Ribble Valley Borough Council  
Council Offices  
Church Walk,  
Clitheroe  
Lancashire  
BB7 2RA

Phone: 0300 123 6780  
Email: [Kathryn.Walsh@lancashire.gov.uk](mailto:Kathryn.Walsh@lancashire.gov.uk)  
Your ref: 3/2024/0700  
Our ref: 3/2024/0700/HDC/KW  
Date: 08 October 2024

**Location:** Park Farm Whalley Road Barrow BB7 9LB  
**Proposal:** Proposed demolition of framed agricultural building in yard, stone lean-to 'electric' building to front and conversion of stone agricultural barn and shippon to create two, two-storey dwellings with associated parking and curtilage areas.  
**Grid Ref:** 374476 438773

Drawing No 01A

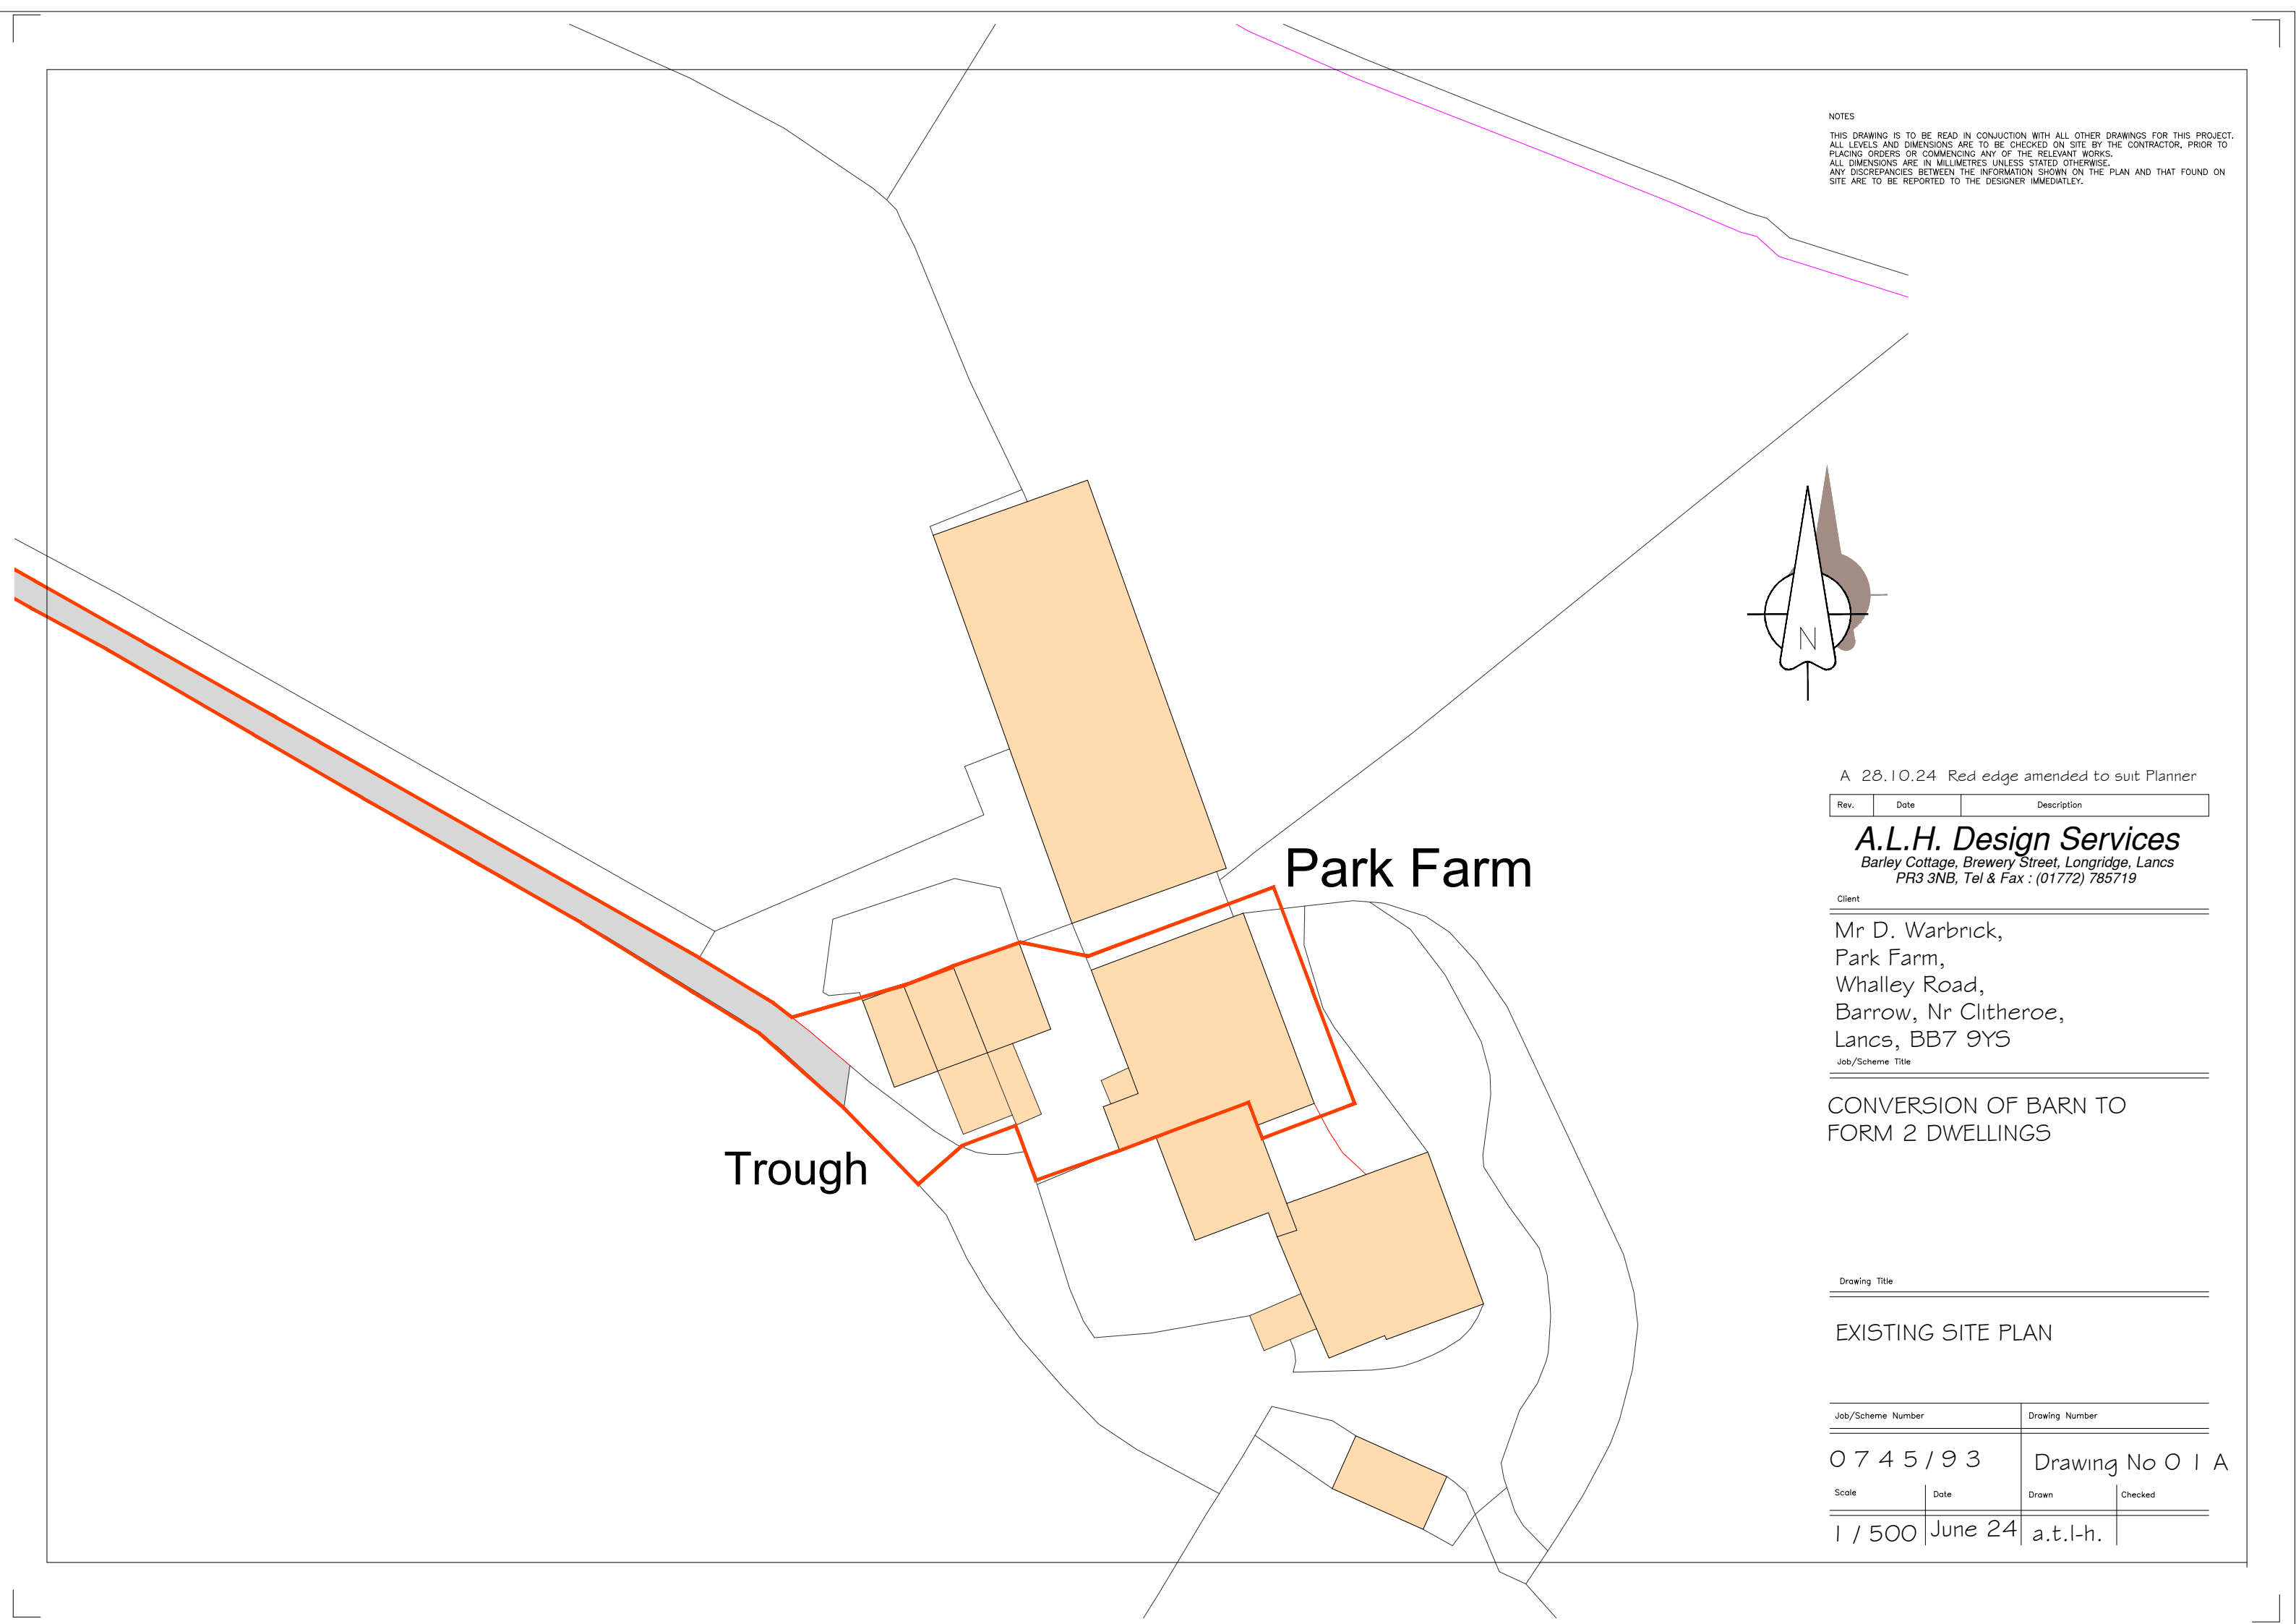
The LHA has reviewed drawing number 0 7 4 5 / 9 3, 0 0 titled Location plan and is aware that the site access will remain unaltered following the proposal. The access is an acceptable width to allow 2-way vehicle movement at the access and currently, no accidents have been recorded within the last 5 years within the vicinity of the access. Therefore, the LHA have no further comments to make regarding the access.

Job/Scheme Number	Drawing Number
0745/93	Drawing No 06A

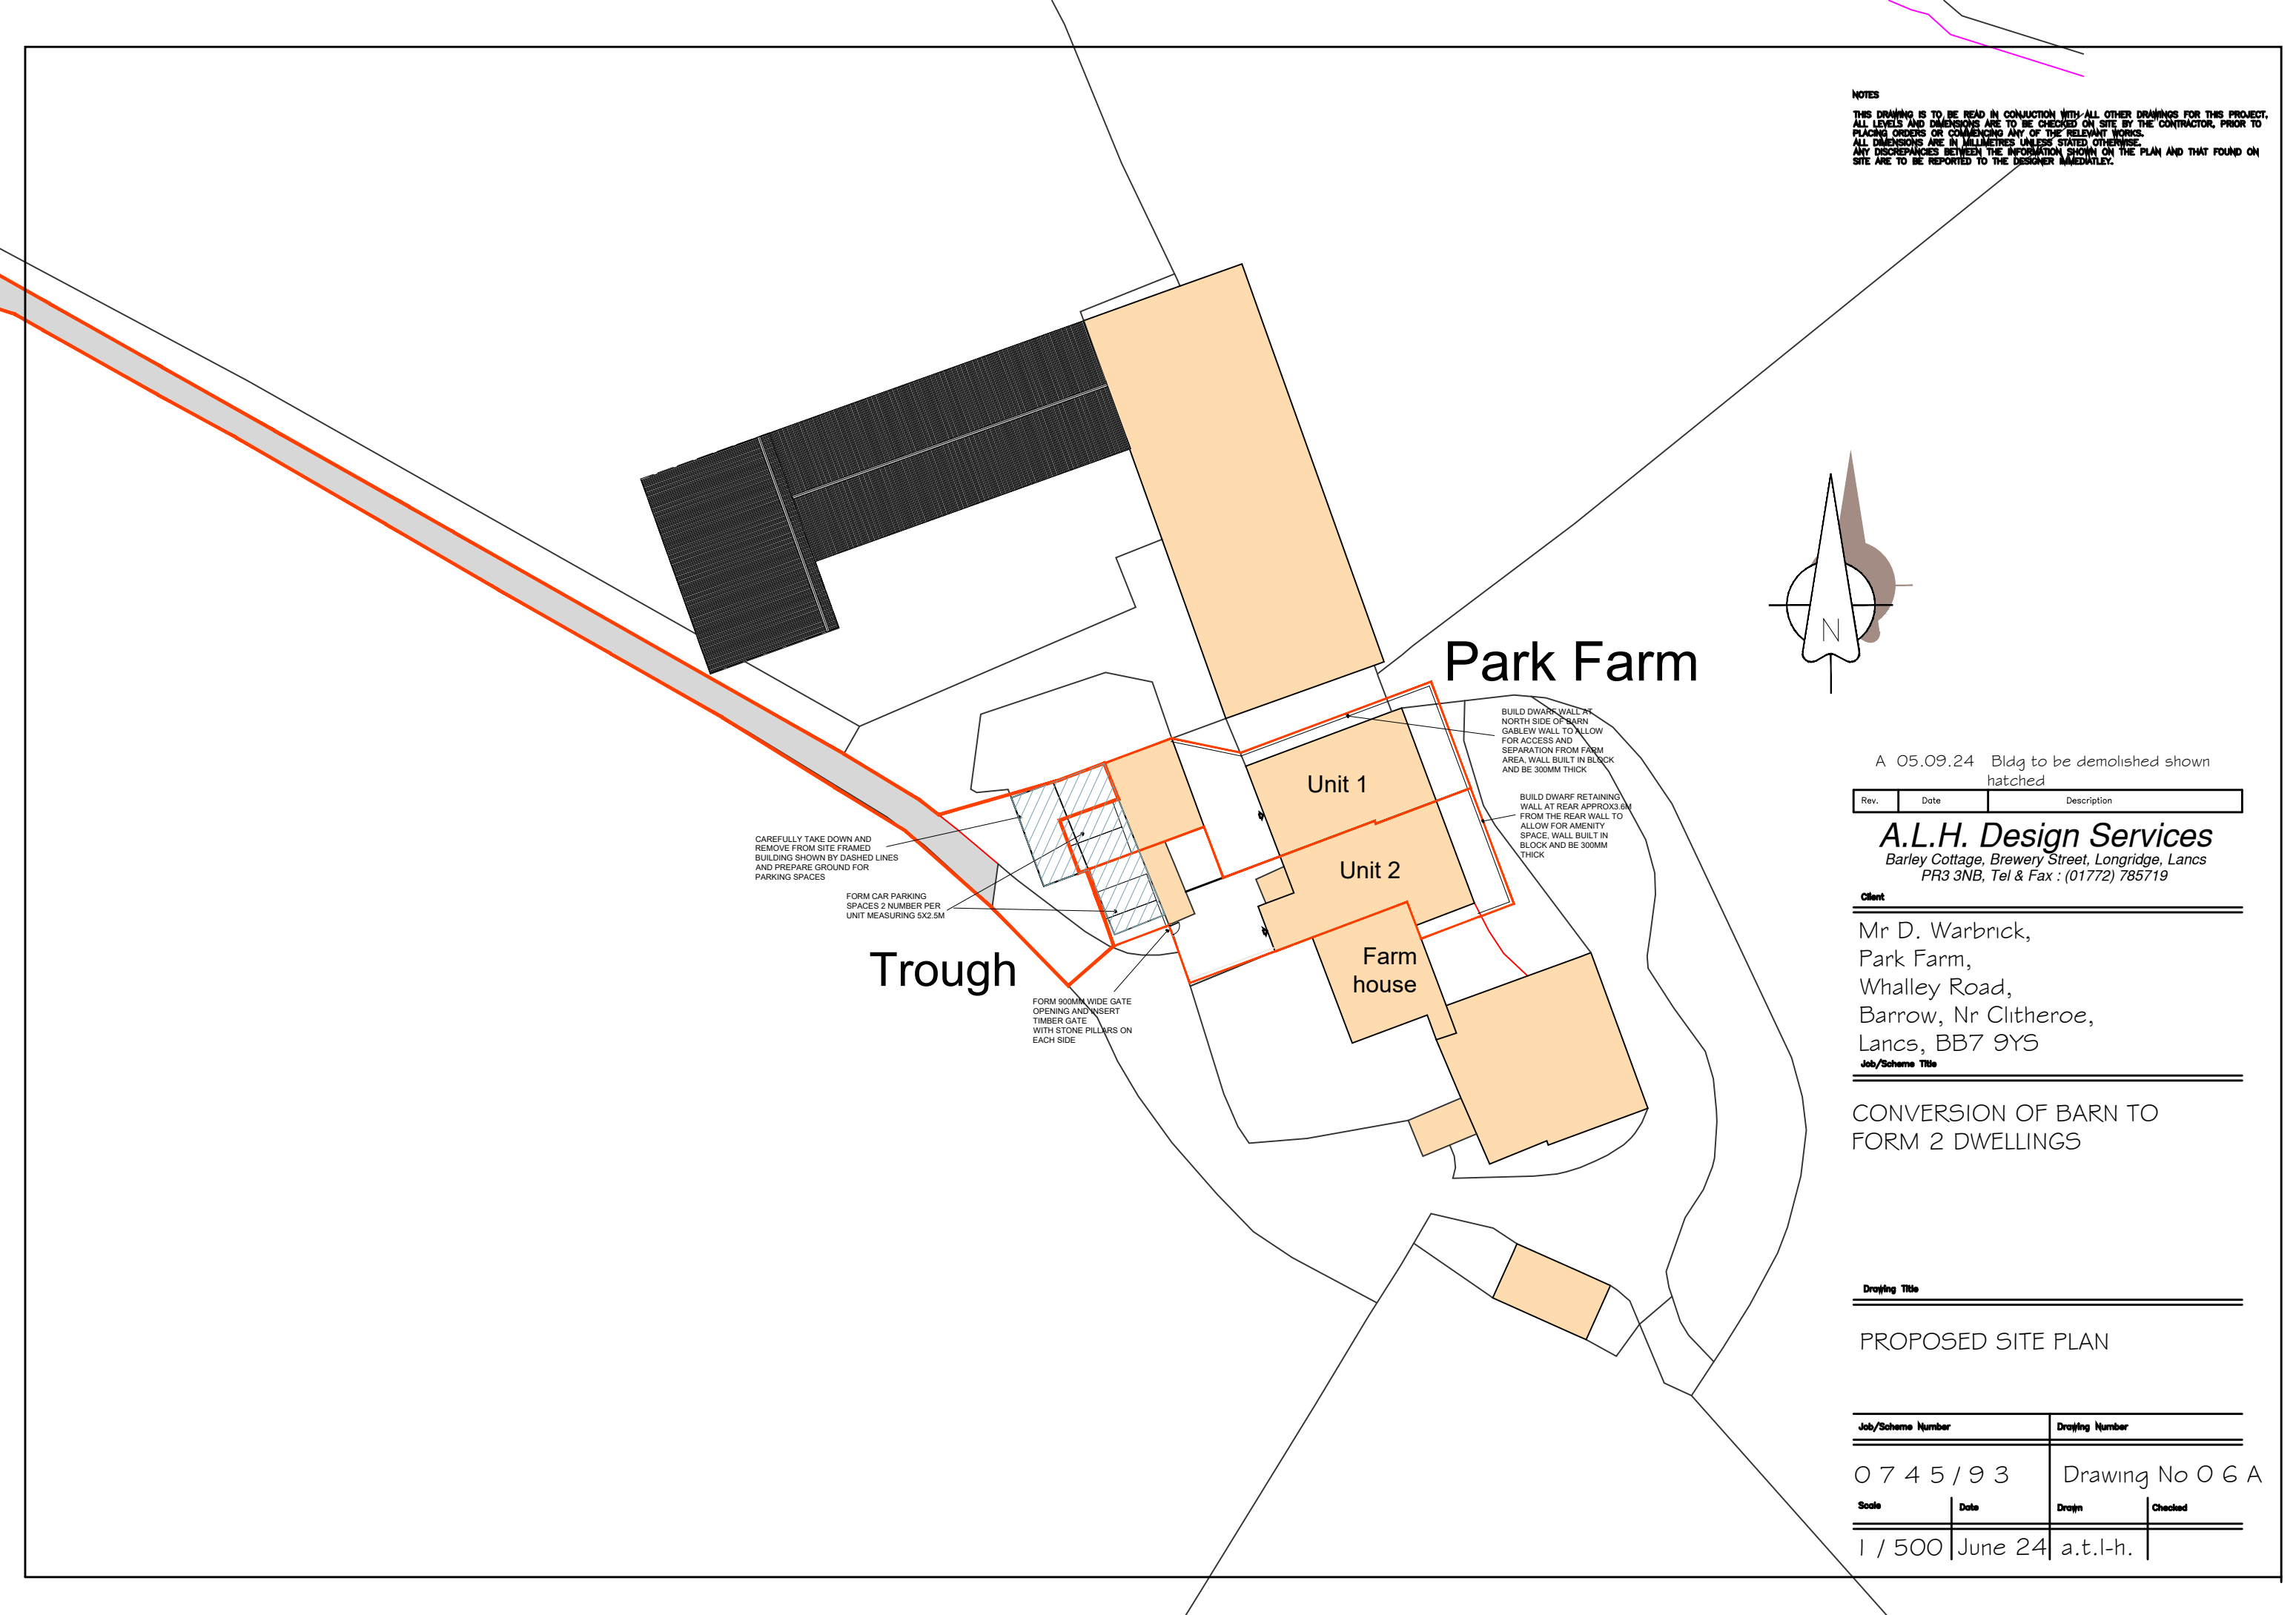
The LHA has reviewed the site plans drawing number 0 7 4 5 / 9 3, 0 6 and 0 7 4 5 / 9 3, 0 7 and is aware that the dwelling complies with the LHAs parking standards as defined in the Joint Lancashire Structure Plan. There is also room to turn within the site allowing for ingress and egress in a forward gear. Therefore, the LHA have no objection to the proposal.

2. No building or use hereby permitted shall be occupied until the car parking area has been surfaced or paved in accordance with a scheme to be approved by the Local Planning Authority and the car parking spaces and manoeuvring areas marked out in accordance with the approved plan. The car parking area shall thereafter be kept free of obstruction and available for the parking cars at all times.
